City of Portland, Maine - Building or Use Permit Application

Permit No: 2012-50595	Issue Date:	CBL: 344 F024001
---------------------------------	--------------------	----------------------------

Location of Construction: 74 HENNESSY DR	Owner Name: KELLEY PAUL E & MARY A KE	Owner Address: 74 HENNESSY DR	Phone: (207) 797-4983
Business Name:	Contractor Name: William Nutting	Contractor Address: 17 Holmes Rd. Saco	Phone: (207) 283-4019
Lessee/Buyer's Name	Phone:	Permit Type: Additions - Dwellings	Zone: R3
Past Use: Single family	Proposed Use: Same - Single family	Permit Fee:	Cost of Work: \$4,000.00
Proposed Project Description: Building 6' X 10' front porch with stairs - 4' x44"		FIRE DEPT: <input type="checkbox"/> Approved <input type="checkbox"/> Denied <input type="checkbox"/> N/A	INSPECTION: Use Group: Type:
		Signature:	Signature:
PEDESTRIAN ACTIVITIES DISTRICT (P.A.D.)			
Action: <input type="checkbox"/> Approved <input type="checkbox"/> Approved w/Conditions <input type="checkbox"/> Denied			
		Signature:	Date:

Plot Plan

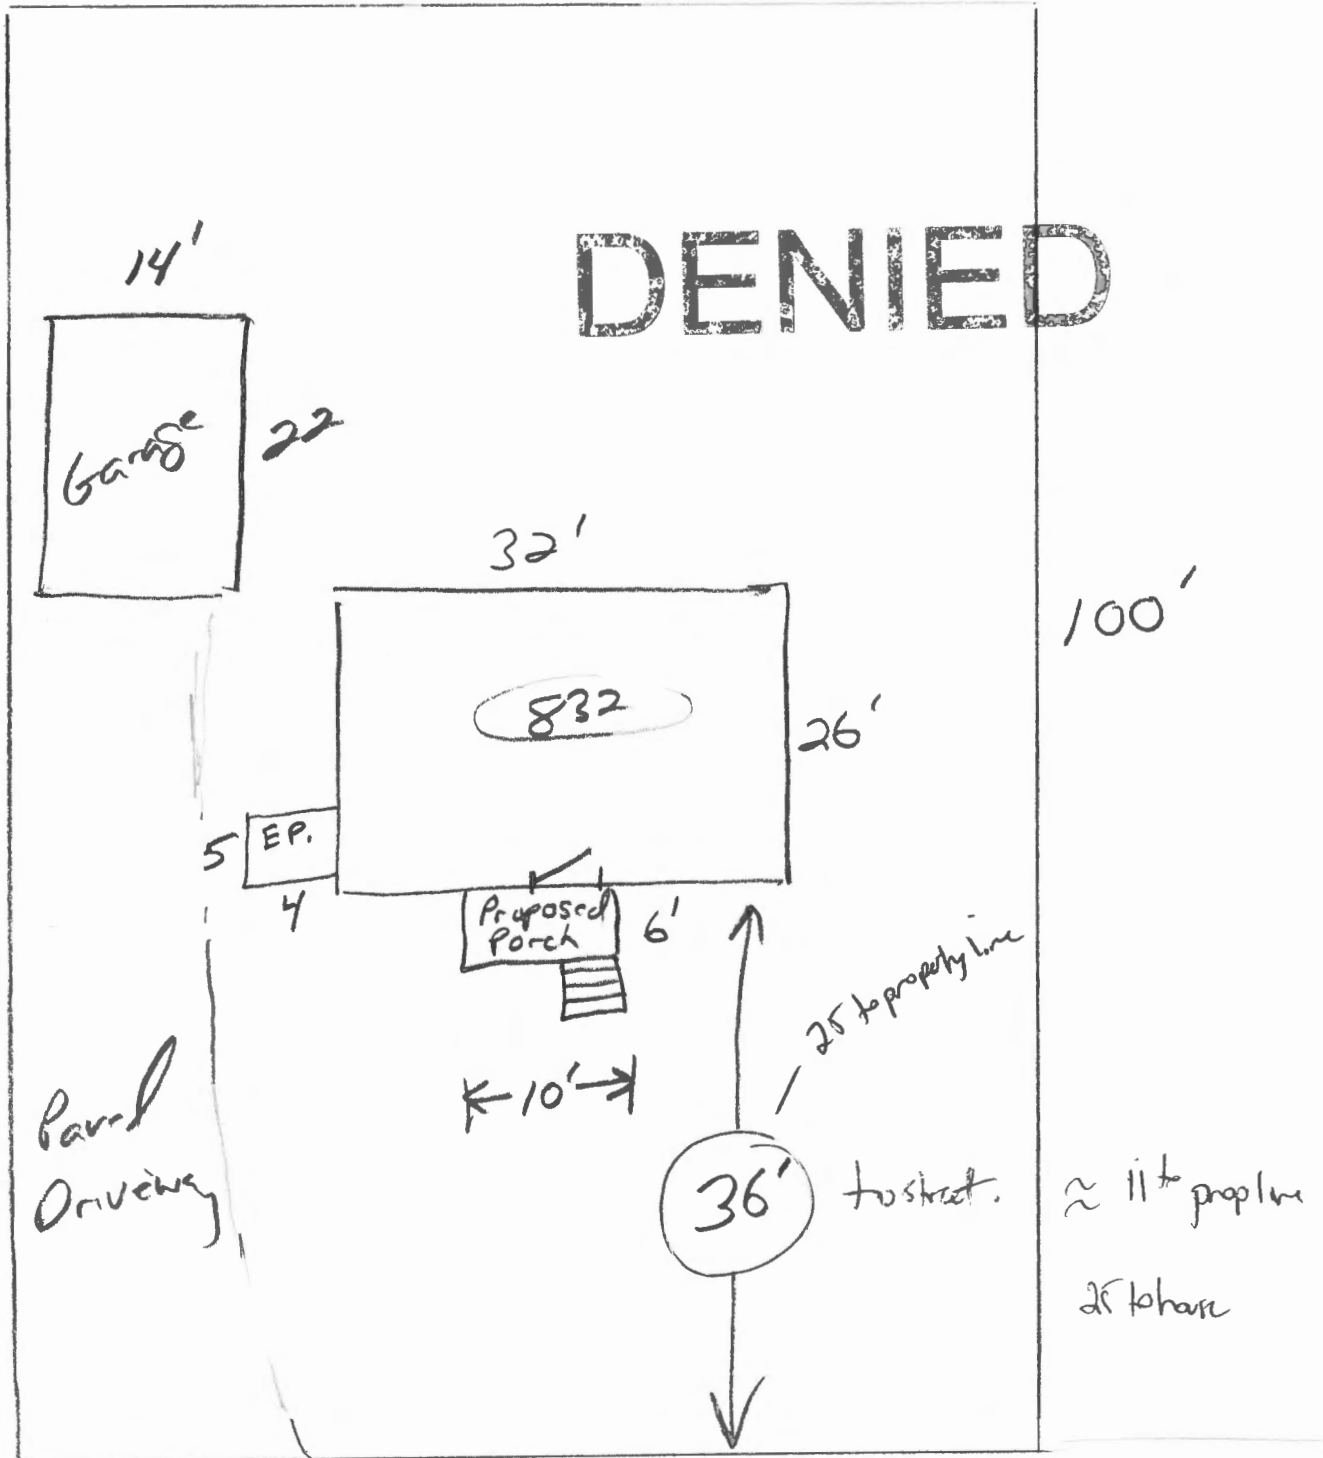
Spoke to contractor, William Nutting. Front setback given on the plot plan is to the street not the front property line. It appears that the proposed porch will not meet the 25' front setback. Permit is on hold until the contractor gets back to me.

Spoke to William Nutting, contractor. He withdrew the application.
